Ribble Valley Borough Council  
Housing & Development Control

Application no: **3/2022/0535**

Address: **Land Adjacent to Woodacre Cottage Fleet Street Lane Ribchester  
PR3 3ZA**

Proposal: **Outline application for the erection of 1 detached dwelling with all  
matters reserved save for access.**

Proposed Site Plan SCALE 1:500

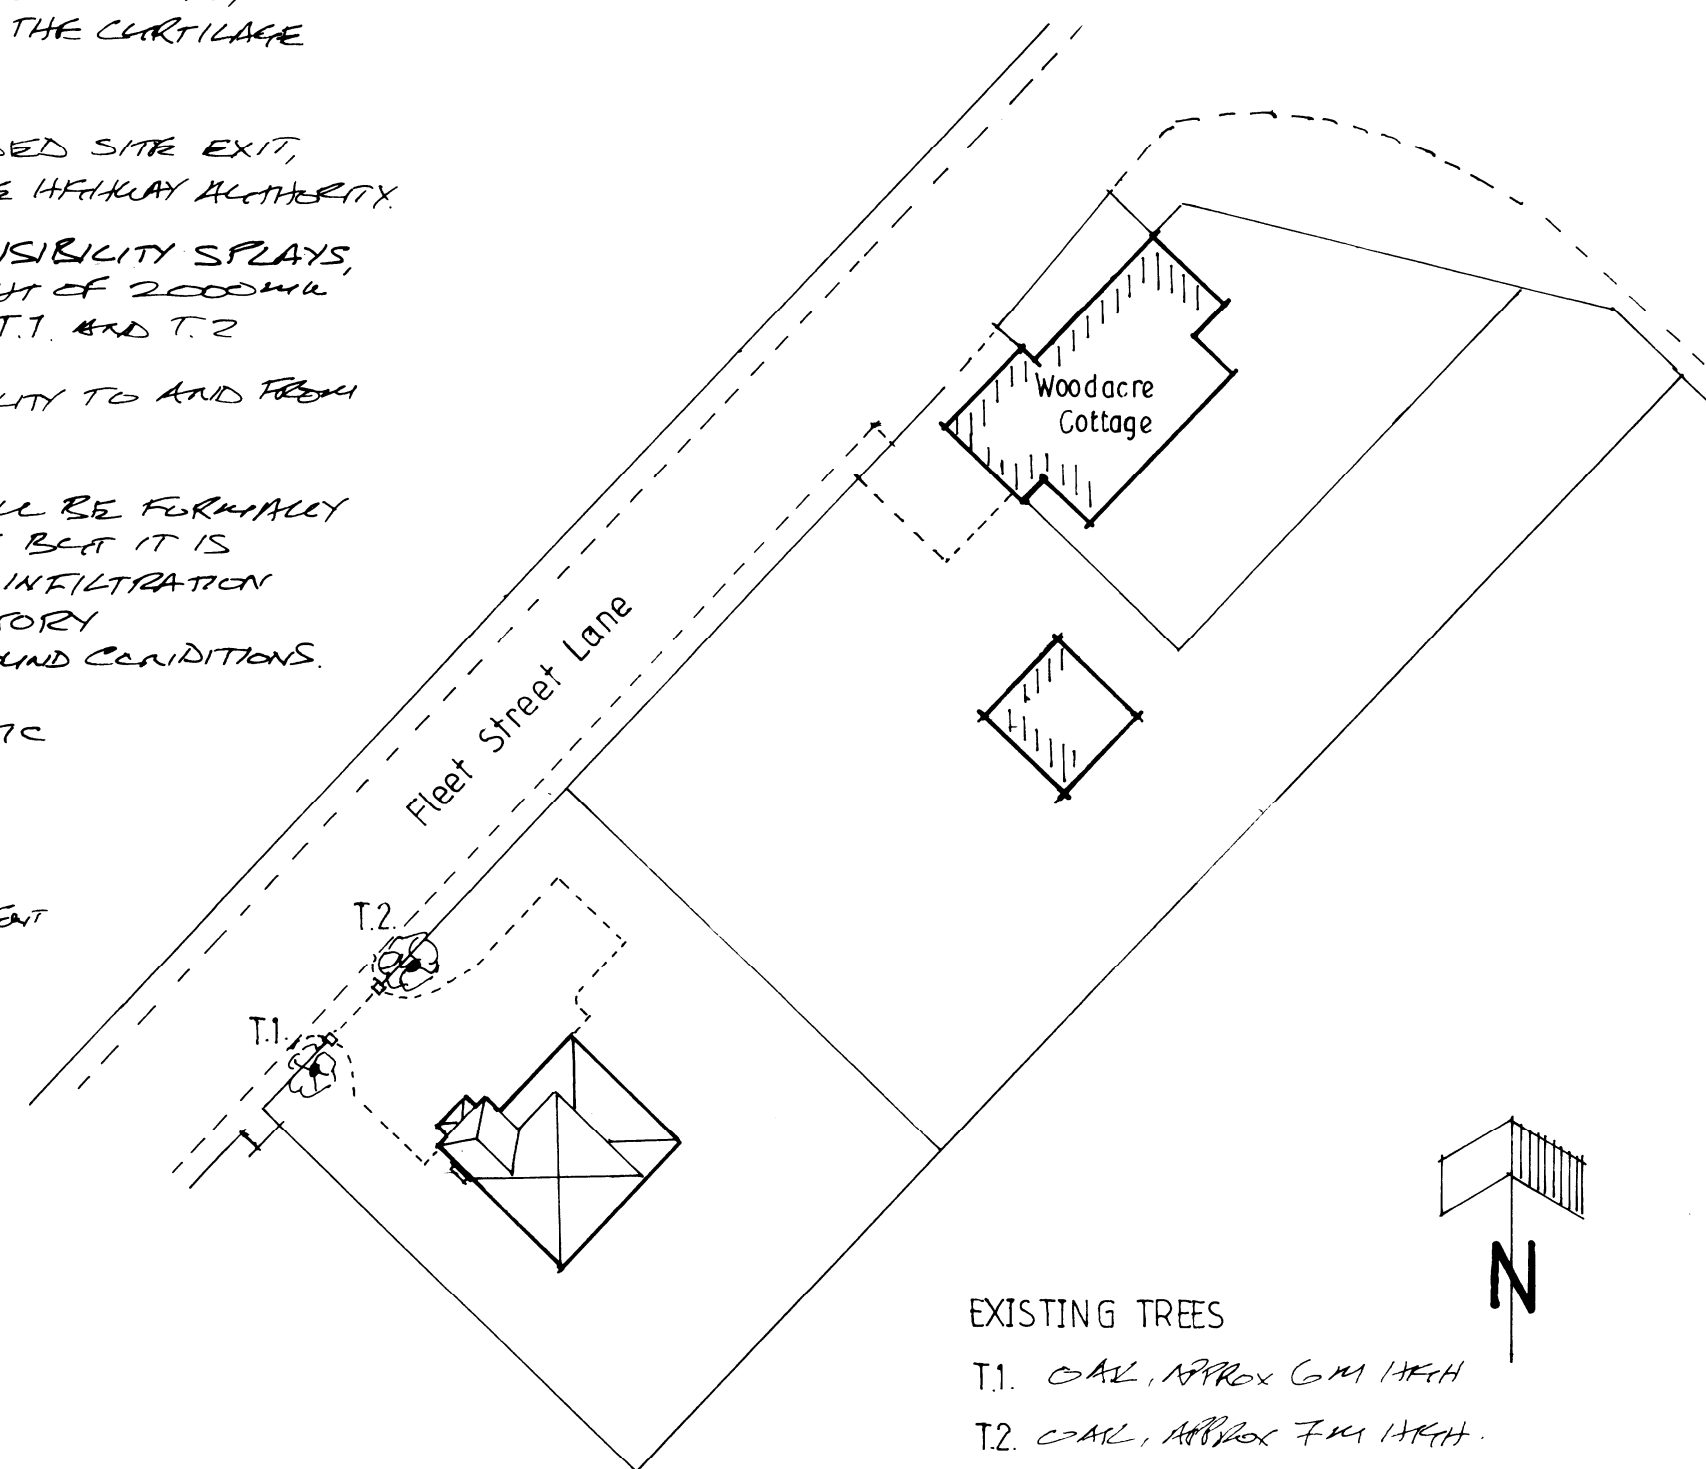
The LHA have reviewed drawing number HAM/2022/01 and are aware that proposal will create a new access to serve the proposed dwelling. The LHA have reviewed the access width and are aware that the width complies with the LHAs guidance when serving a single dwelling.

However, for the LHA to support the creation of a new access on a 60mph road a visibility splay drawing is required. The LHA remind the Agent that an access served off a 60mph road is required to provide visibility splays of 2m x 214m in both directions to comply with the LHAs guidance.

Should the access not be able to achieve the minimum visibility, the LHA require a speed survey to be conducted evidencing the 85<sup>th</sup> percentile speeds along Fleet Street Lane within the vicinity of the site access. A visibility splay drawing should also be submitted to complement the findings.
